PROJECT NO. PR-2020-004820

# Memorandum

**Re:** Hotel Circle Ramada Apartment Conversion DRB Comment Responses (PR-2020-004820)

SHEET TITLE
SITE UTILITY PLAN
 SHEET NUMBER
CU-101

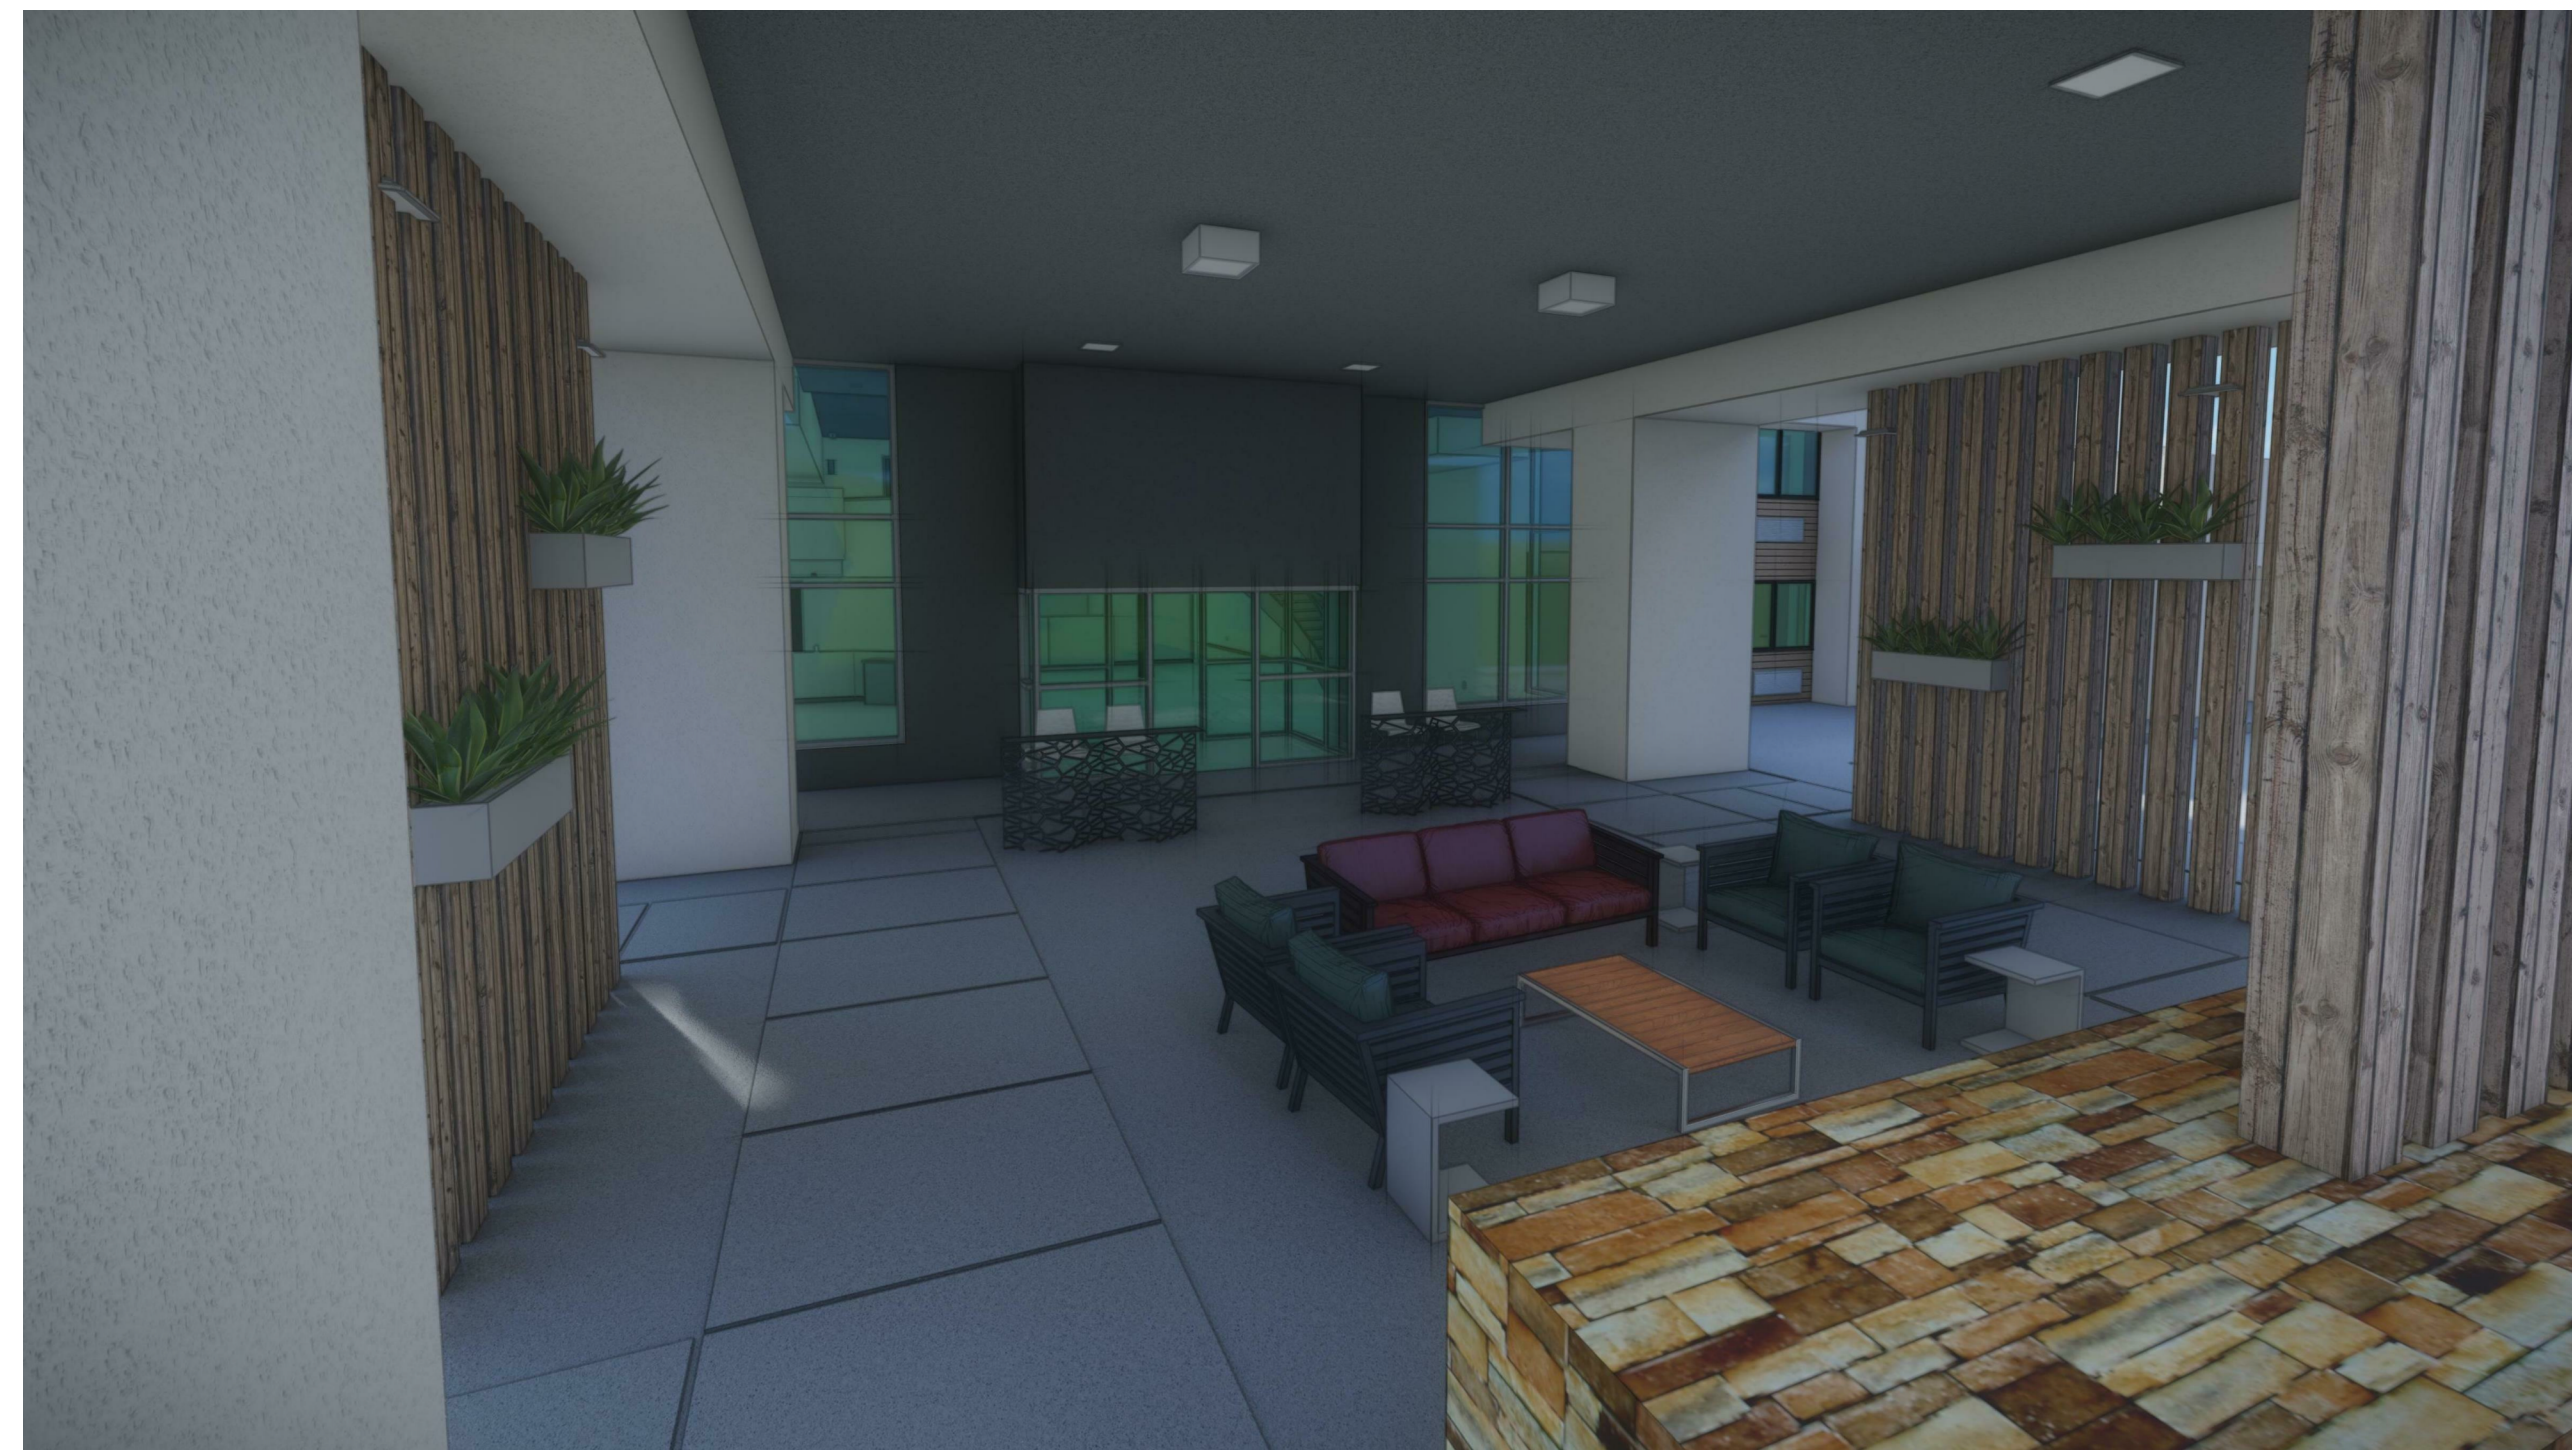
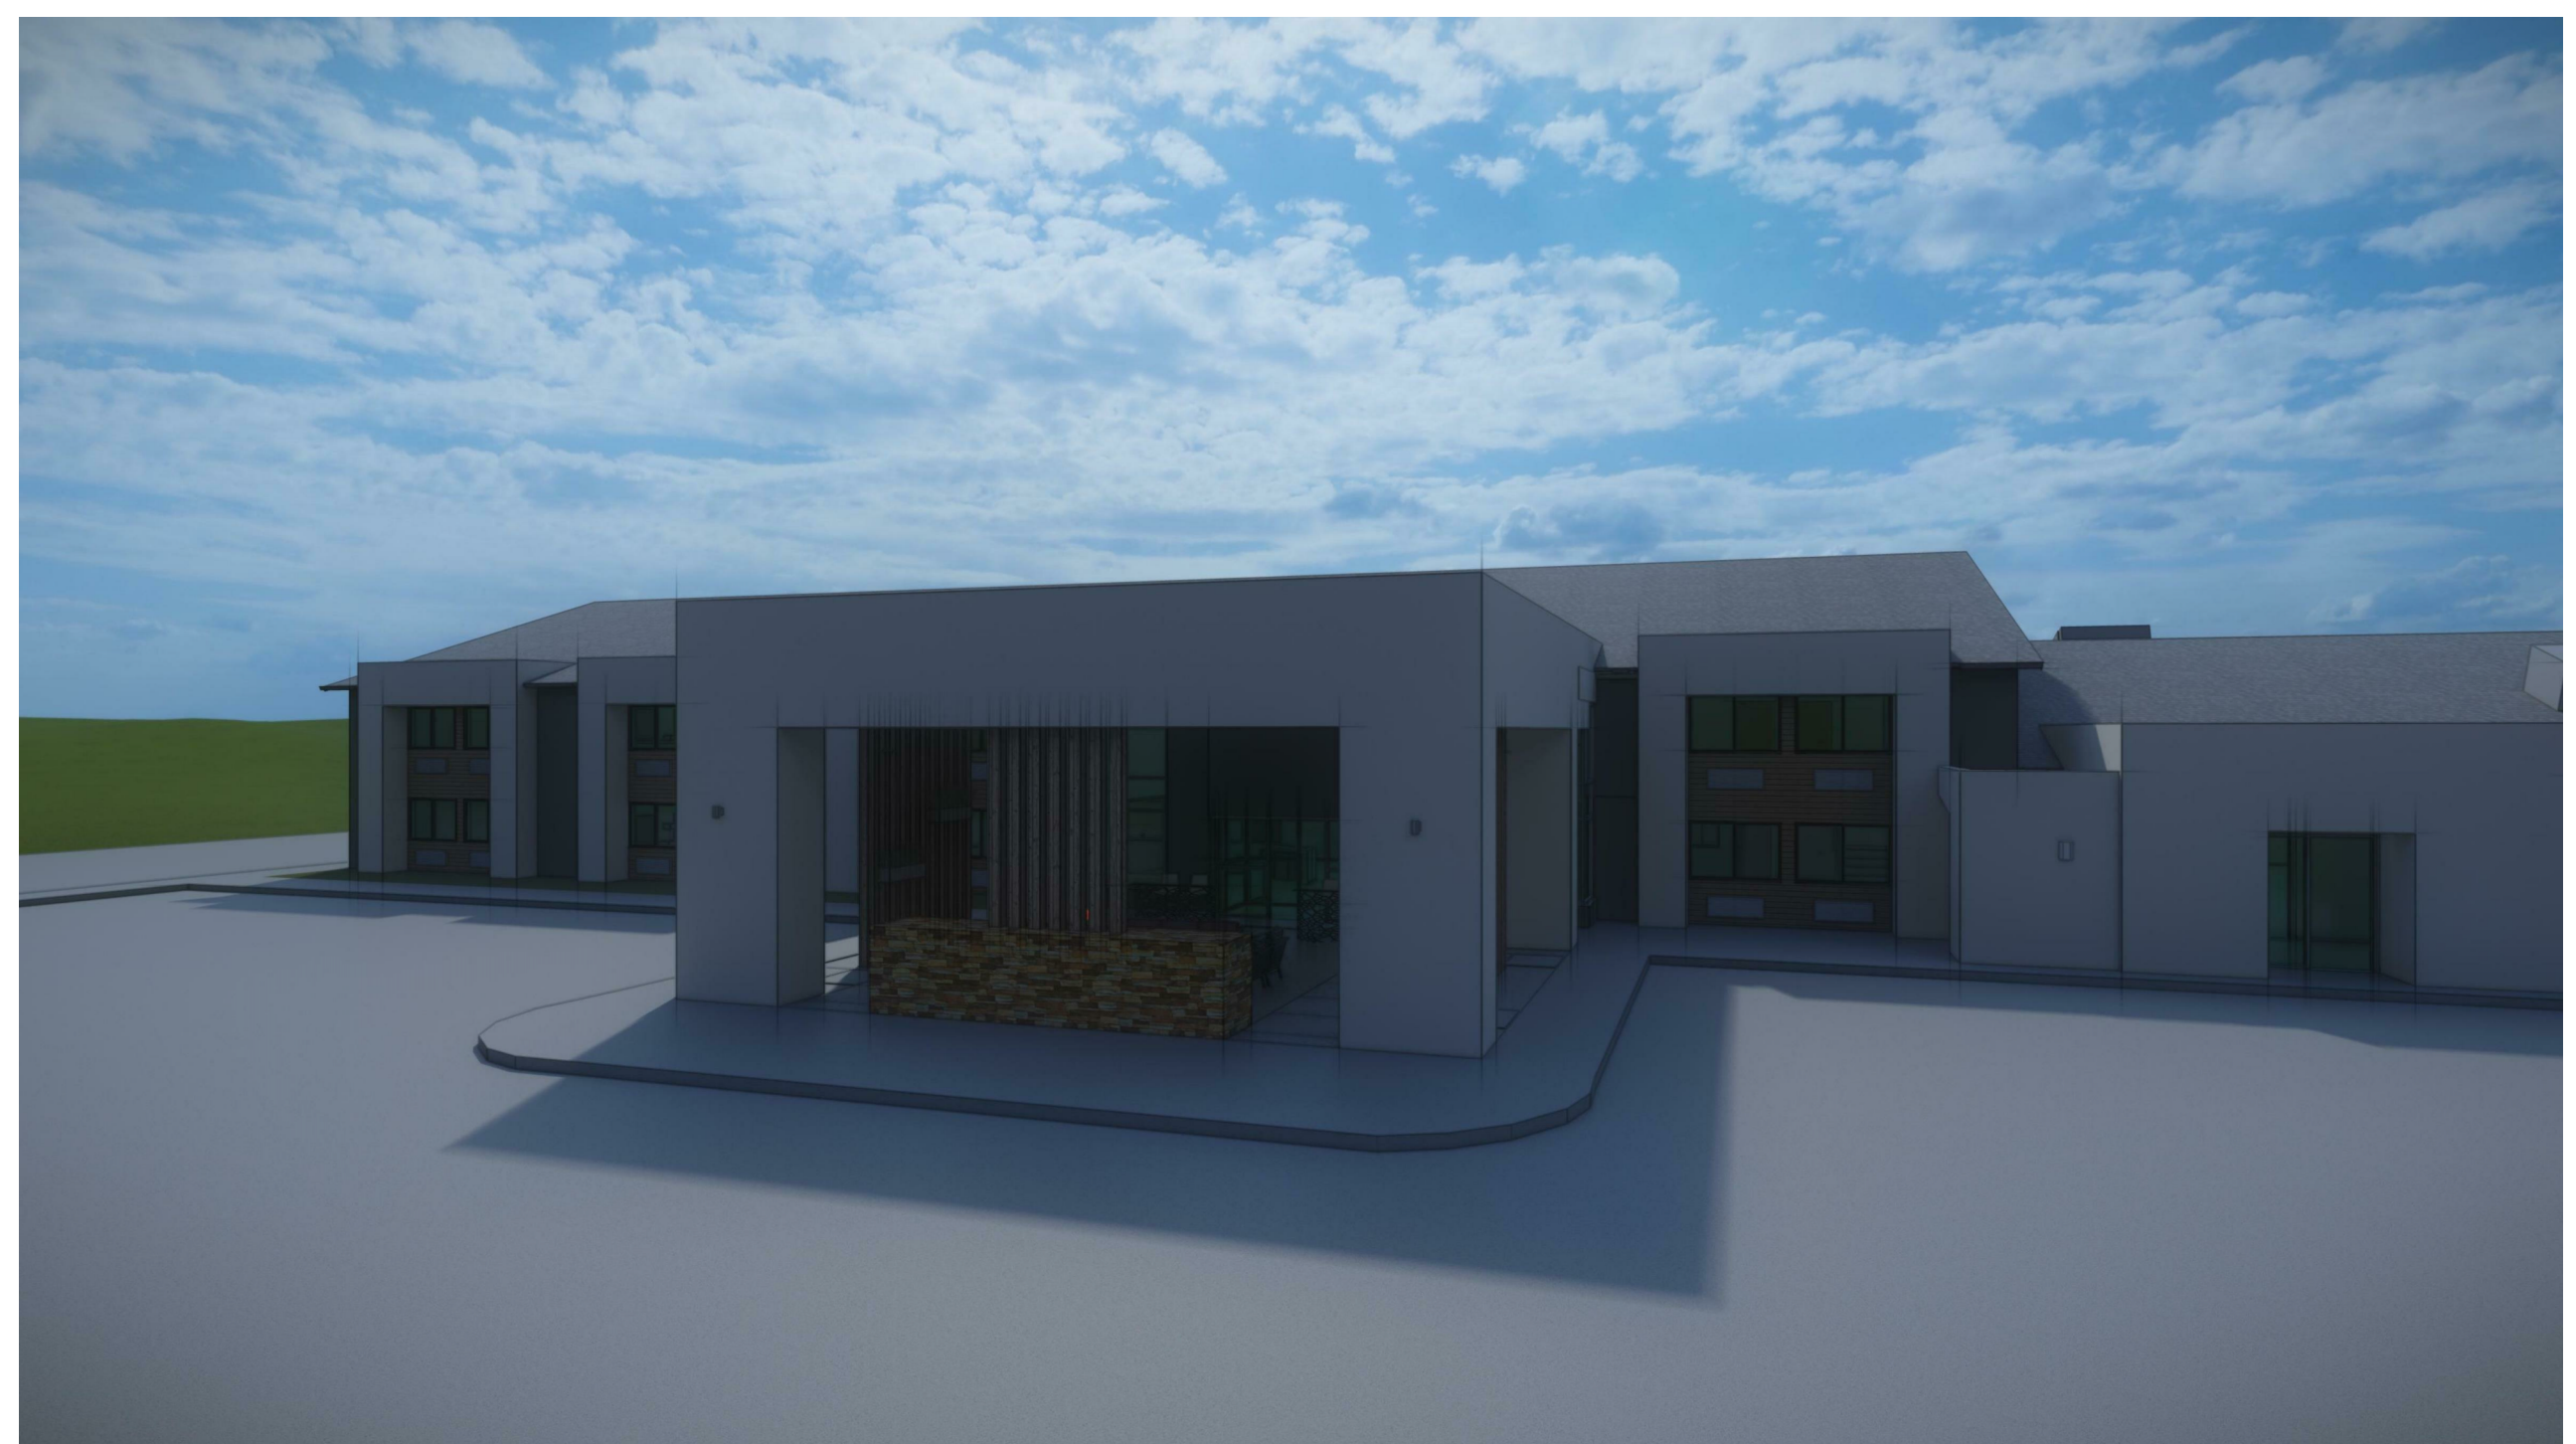
- a. For various reasons, the restaurant use has been removed from the proposed site plan at this time, so additional services should not be necessary. The intent is for the multi-family development to utilize the existing 3" water meter and the customer class will be adjusted accordingly.**
3. Please provide a utility plan.  
Please show existing onsite public waterline and sanitary sewer.
    - a. Existing utility lines and easements are shown on the site plan. A separate utility plan is also included with the rest of the plan set.**

EXISTING TREE CALIPER

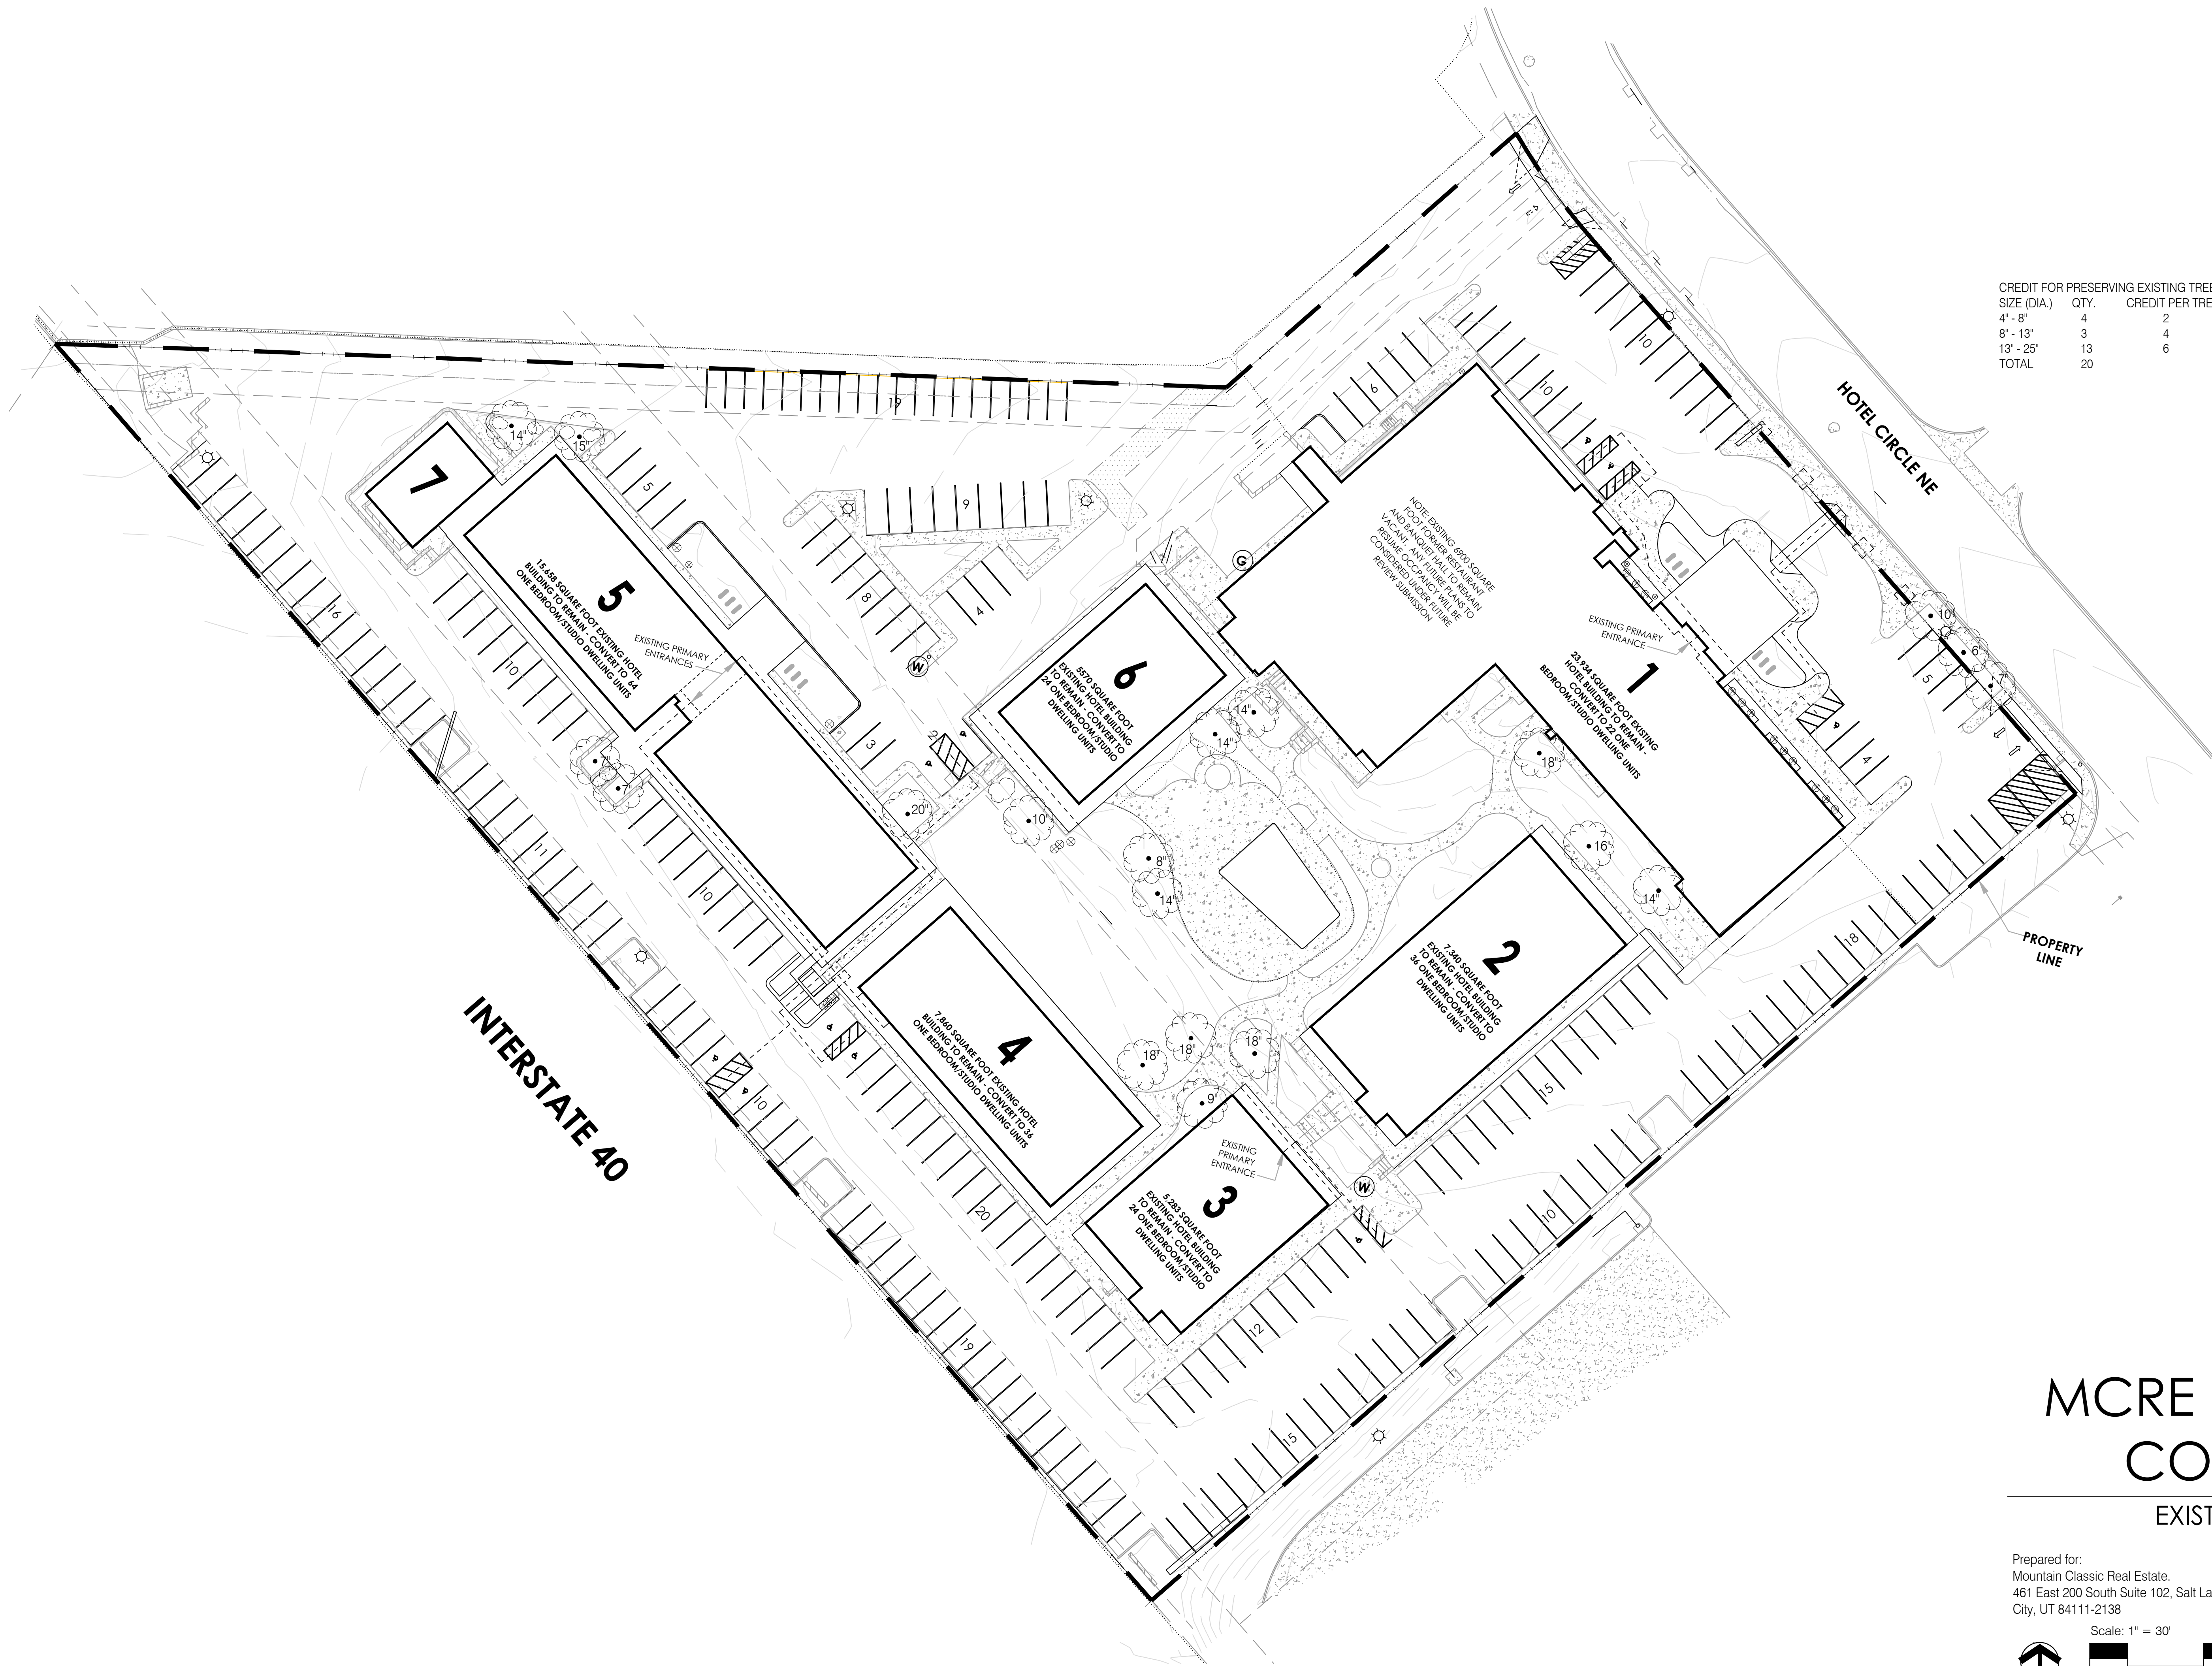
1. Please verify existing tree sizes for tree credit.
  - a. We have created an exhibit that shows the measured caliper of each existing tree and translates that measurement to IDO Table 5-6-2 and the calculations shown on the landscape plan.**
